Viking CCS Pipeline

9.40 Design Changes 3 and 4: Environmental Technical Note

Document Reference: EN070008/EXAM/9.40

Applicant: Chrysaor Production (U.K.) Limited,
a Harbour Energy Company
PINS Reference: EN070008
Planning Act 2008 (as amended)
The Infrastructure Planning (Applications: Prescribed Forms
and Procedure) Regulations 2009 - Regulation 5(2)(q)
Date: June 2024

Drawing file: EN070008 / EN070008-000217-EN070008_Viking_CCS_Pipeline_4-16_Louth_Road_Block_Valve_Station_Plan_and_Elevations_V1.pdf

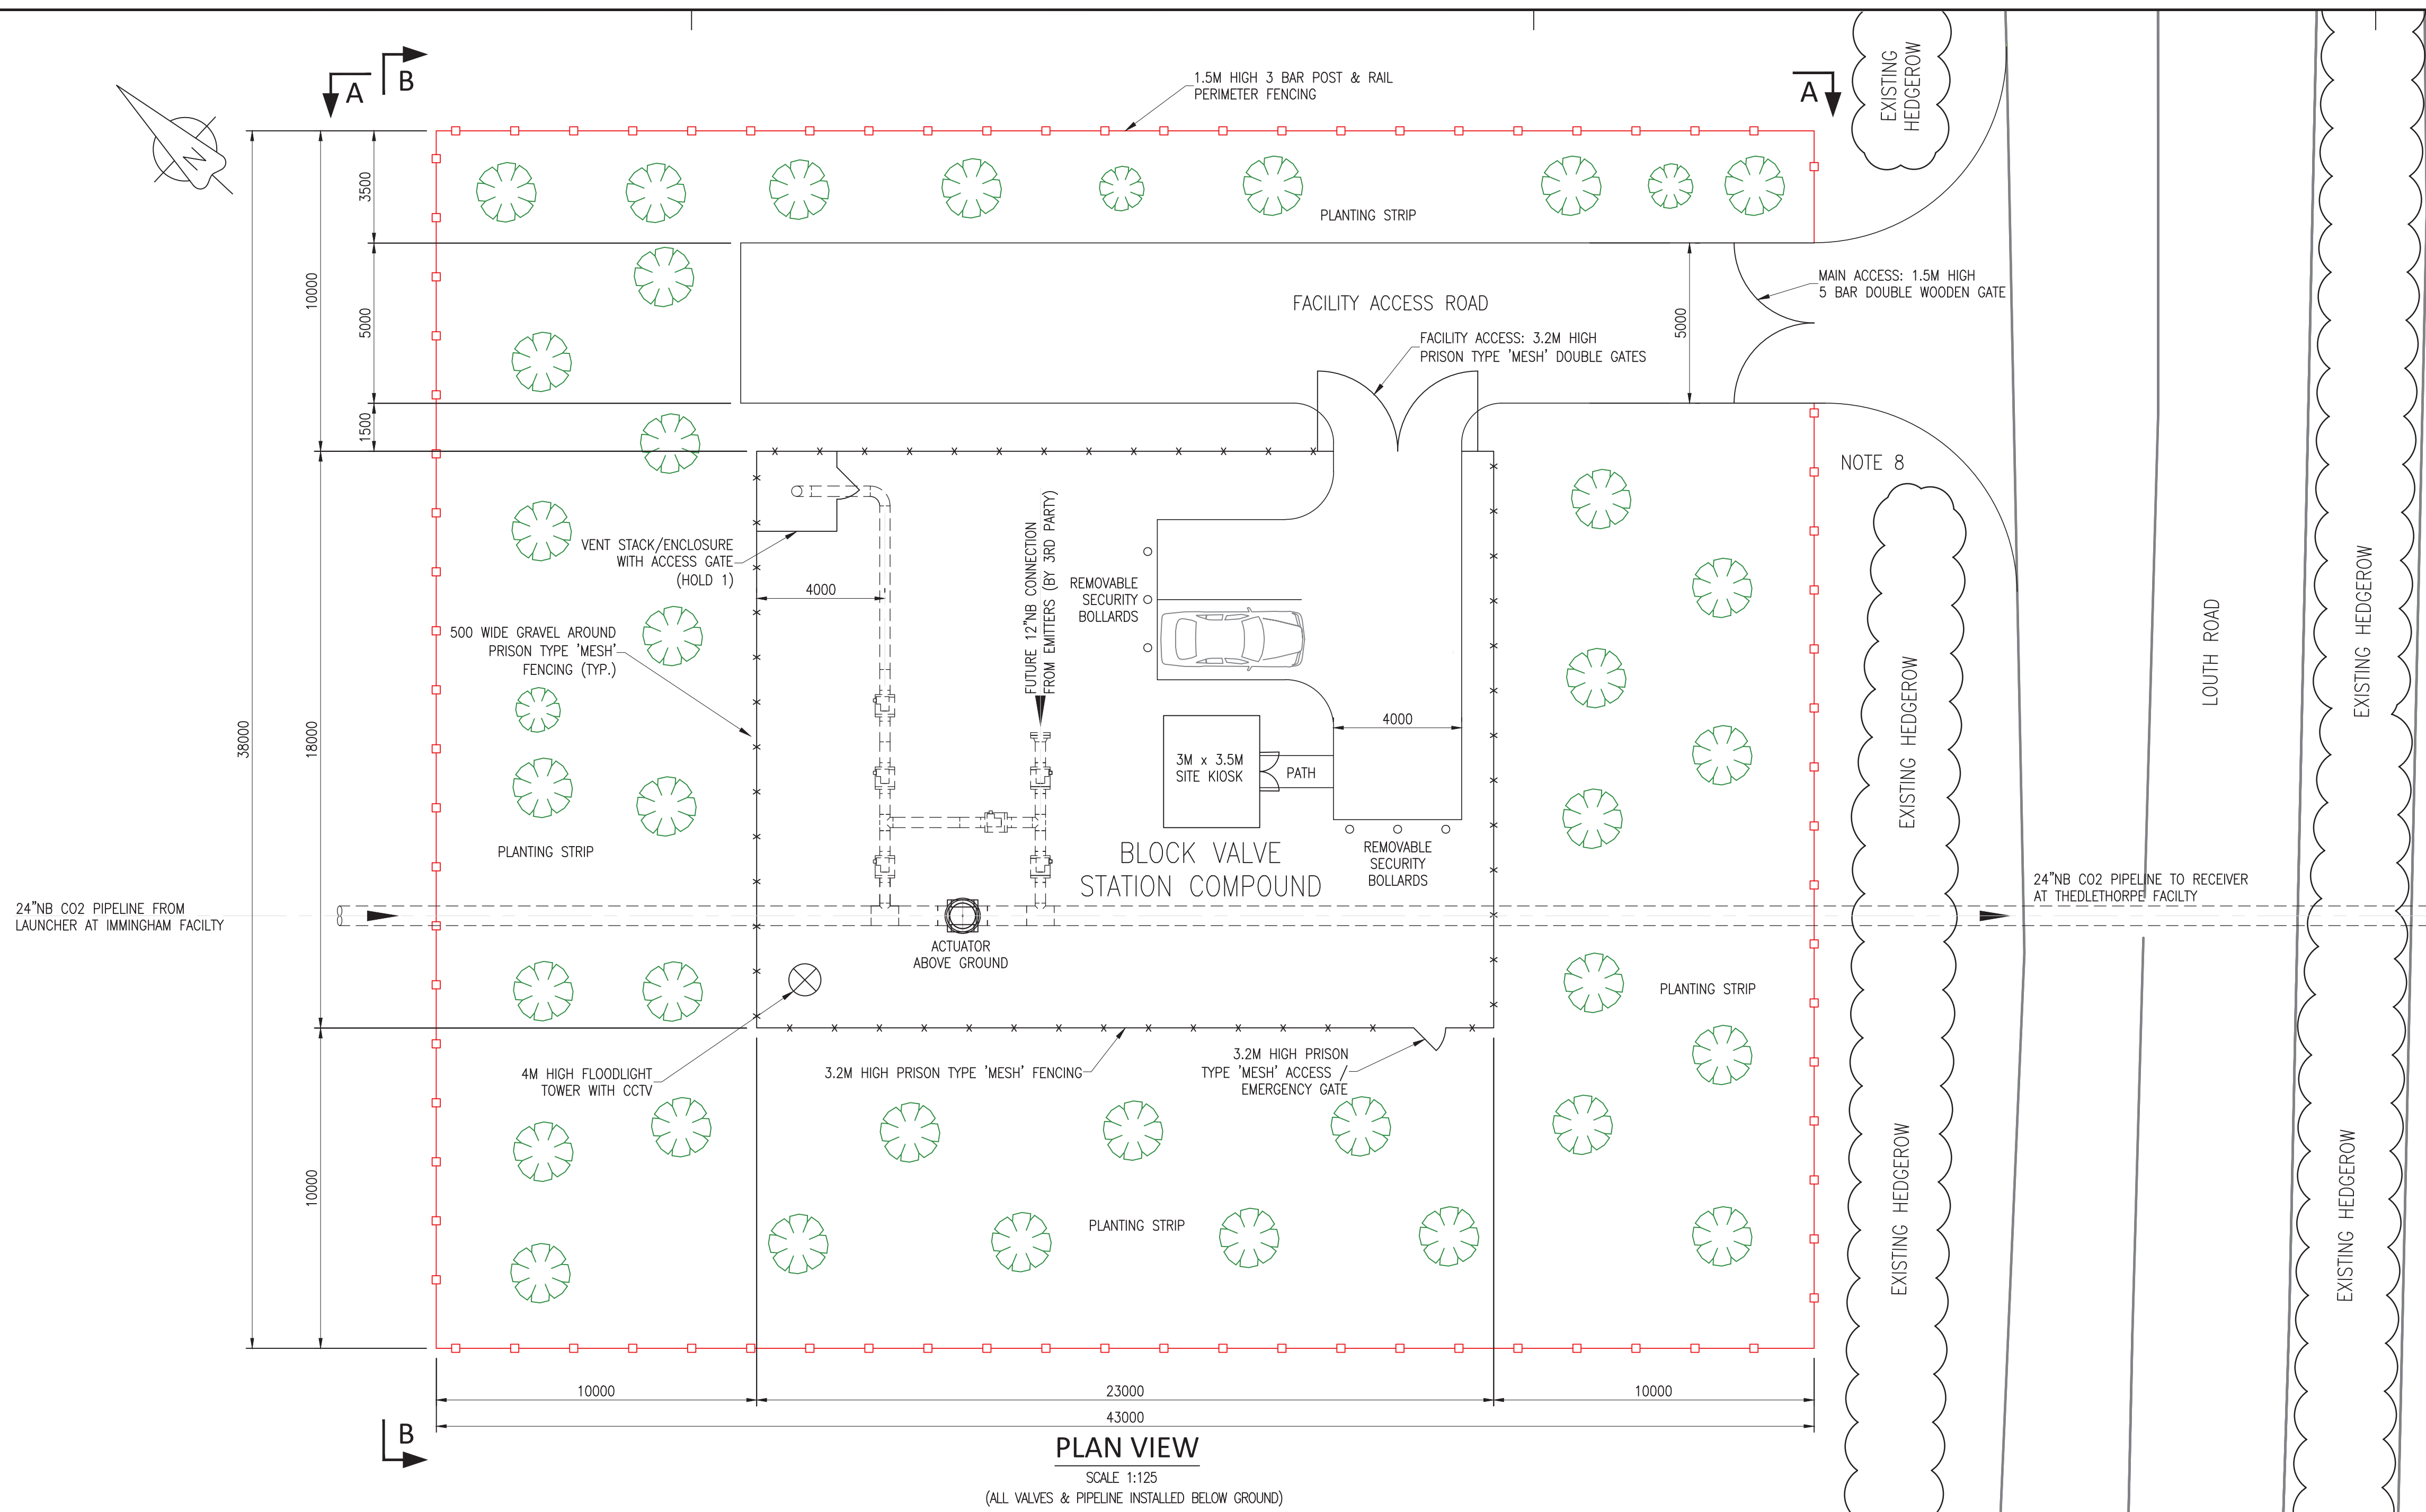
- 1.1.5 Design Change 3 relates specifically to a relocation of Block Valve Station 3 (Louth Road Block Valve Station) within the existing Order Limits, moving it from north of Louth Road to south of the road. Note, this road is often labelled incorrectly as Alvingham Road on mapping services. Design Change 4 relates to a narrowing of the Order limits over land owned by Anglian Water, immediately south east of Block Valve Station 3.

- The proposed location of Block Valve Station 3 is proposed to be moved from arable land north east of Louth Road, approximately 20 m south to arable land south east of Louth Road. Importantly, this change does not require any change to the Order Limits for the Proposed Development;
- The Block Valve Station would have a permanent access point off the south side of Louth Road, rather than to the north;
- A proposed temporary access and laydown area that was originally south east of Louth Road would be relocated to the north west side of Louth Road; and
- As outlined within the Applicant's response to the first written Questions [REP1-045], it has been confirmed that the physical footprint of all Block Valve Station's will be approximately 43 metres x 38 metres (rather than the originally quoted 50m x 40 m in paragraph 3.8.15 in APP-045).

- The anticipated appearance is expected to remain the same as that shown in Figure 3-14 of ES Volume II Chapter 3: Description of the Proposed Development [APP-045], with the orientation updated to reflect its new location as shown in **Figure 3**.

FIGURE TITLE  
 FIGURE 3  
 LANDSCAPE PLAN  
 LOUTH ROAD BLOCK VALVE STATION  
 SHEET 3  
 ISSUE PURPOSE  
 ENVIRONMENTAL STATEMENT  
 PROJECT NUMBER / REFERENCE  
 60668955 / VCCS\_230620\_ES\_2

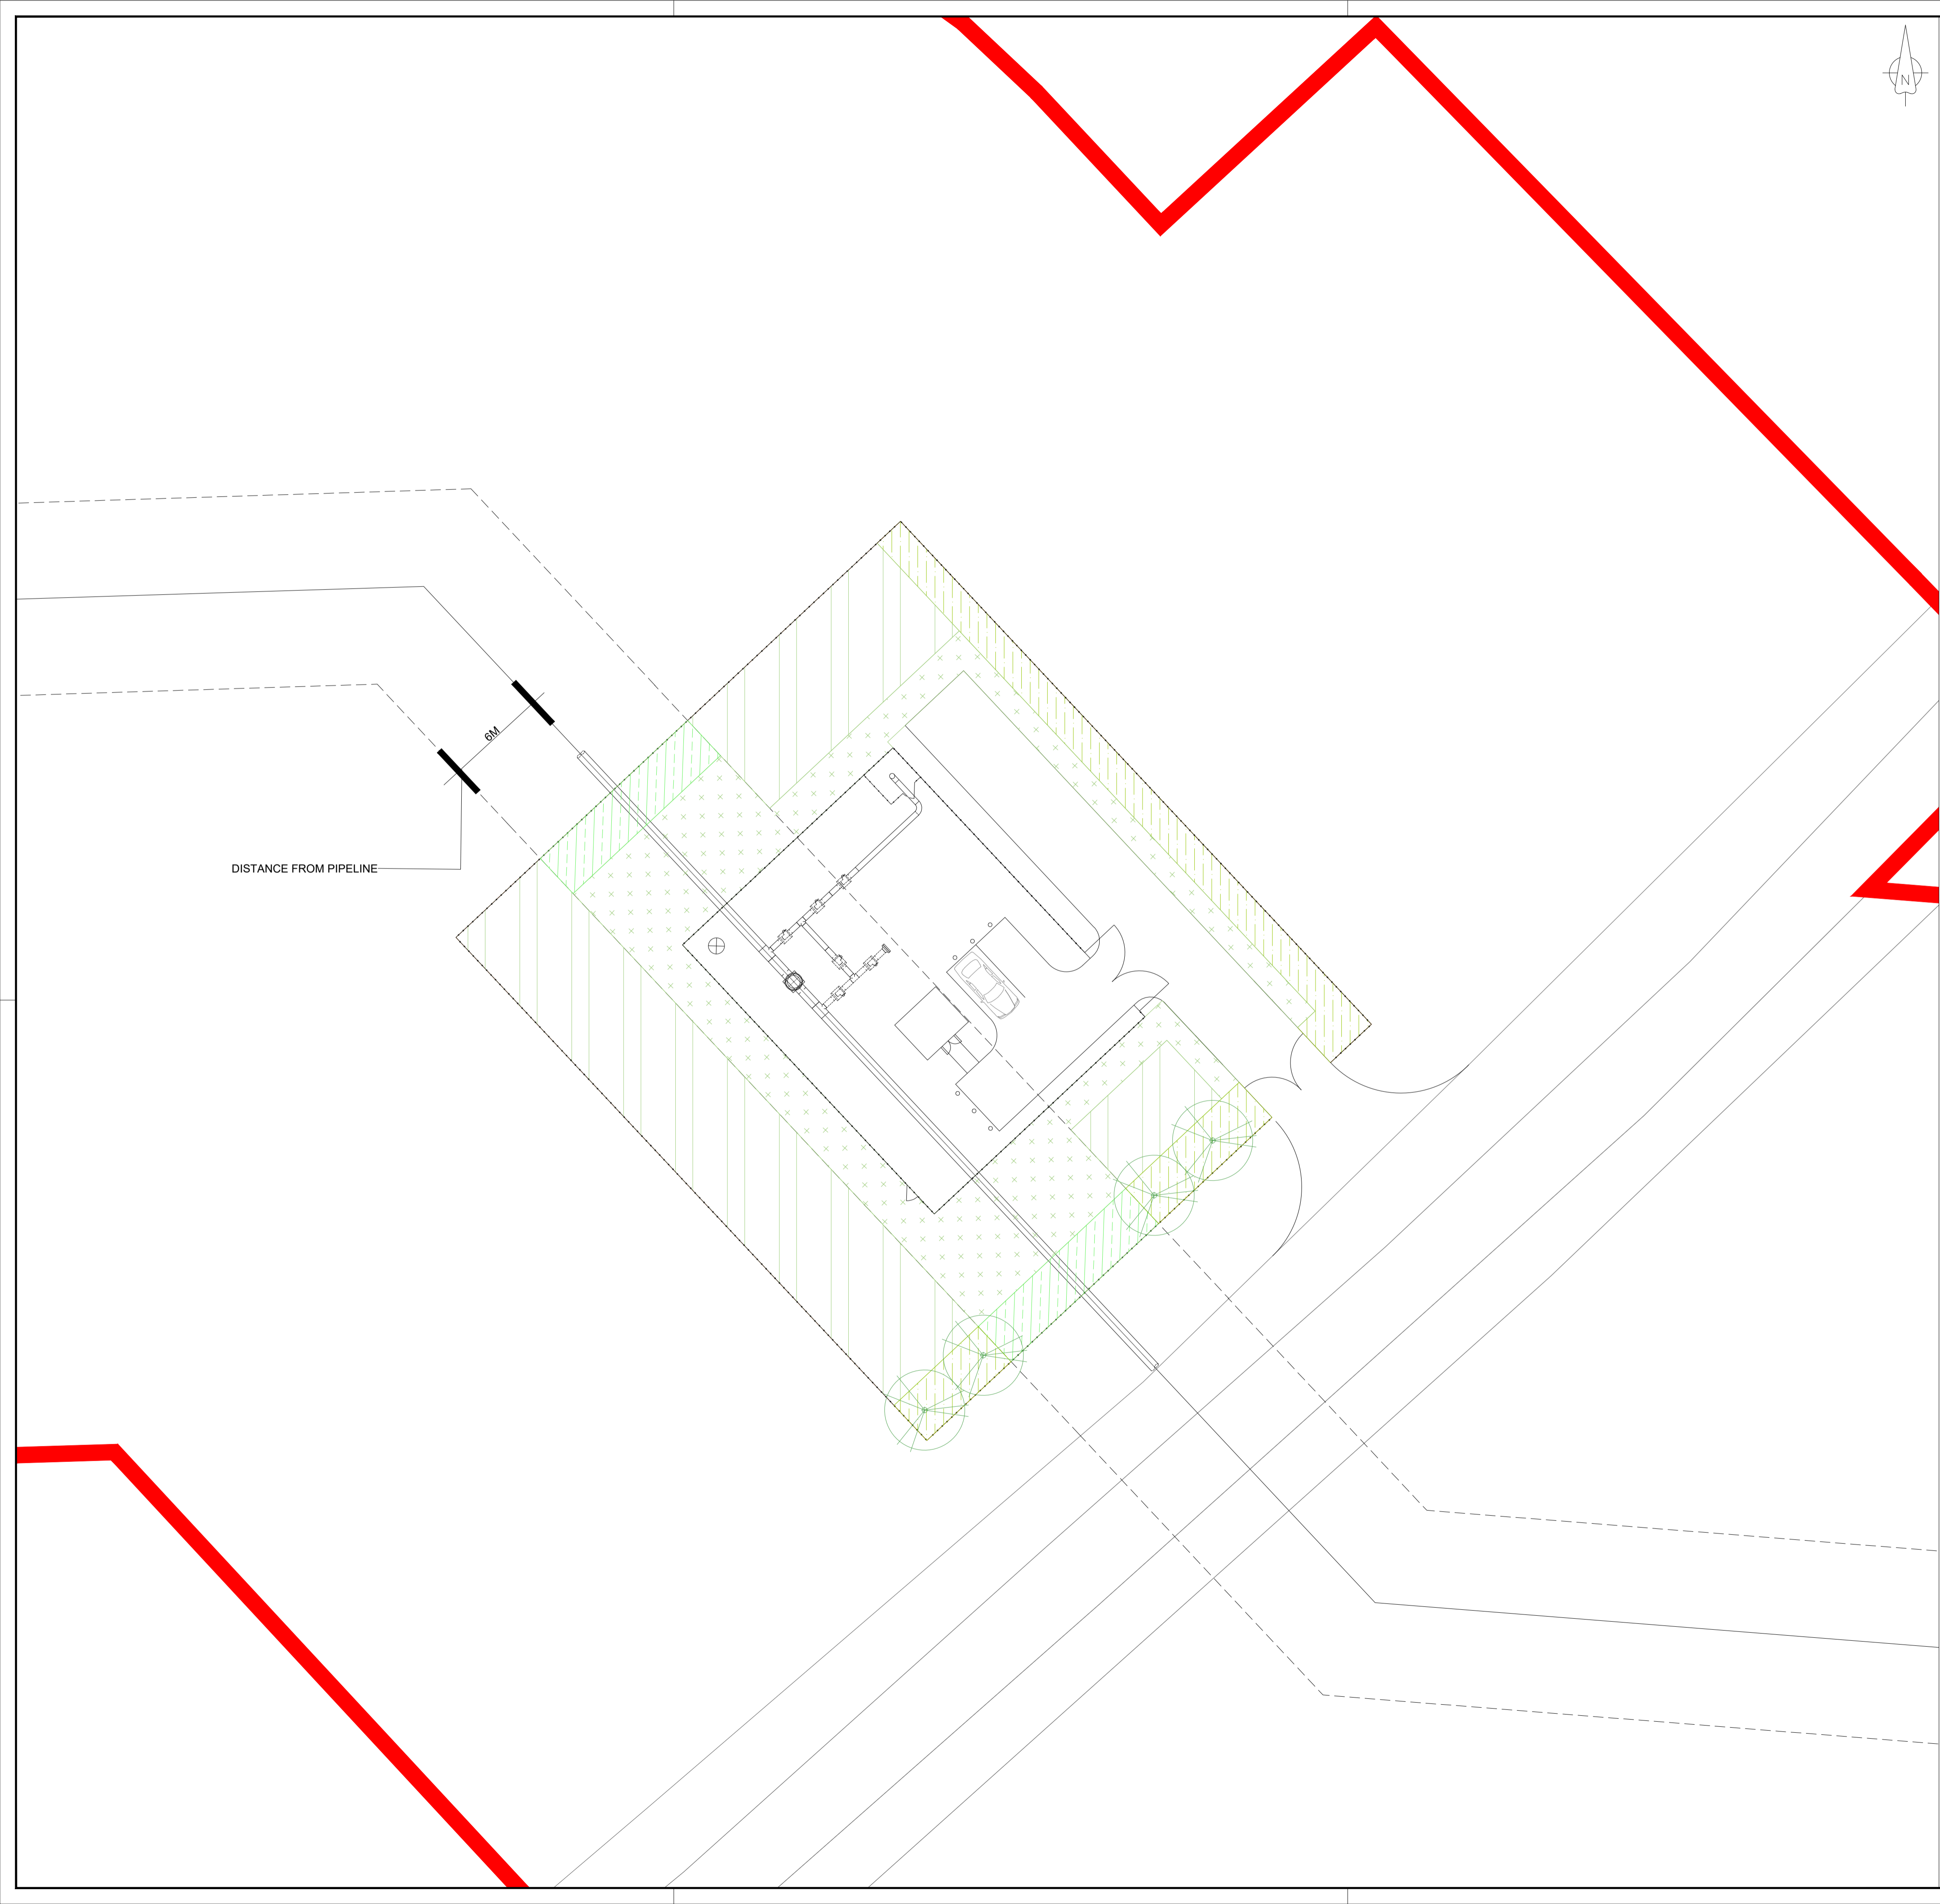
- The Block Valve Stations would include a 10m wide planting strip to provide screening, as outlined in the Outline Landscape and Ecological Management Plan [REP2-026]. Outside this visual landscaping, the Block Valve Station will have a smaller 1.5m high three bar, post and rail perimeter fence and access gate. Block Valve Stations would be unlit except during maintenance or potential breakdown/emergency requirements, when task lighting columns (approximately 4 m high) would be employed;
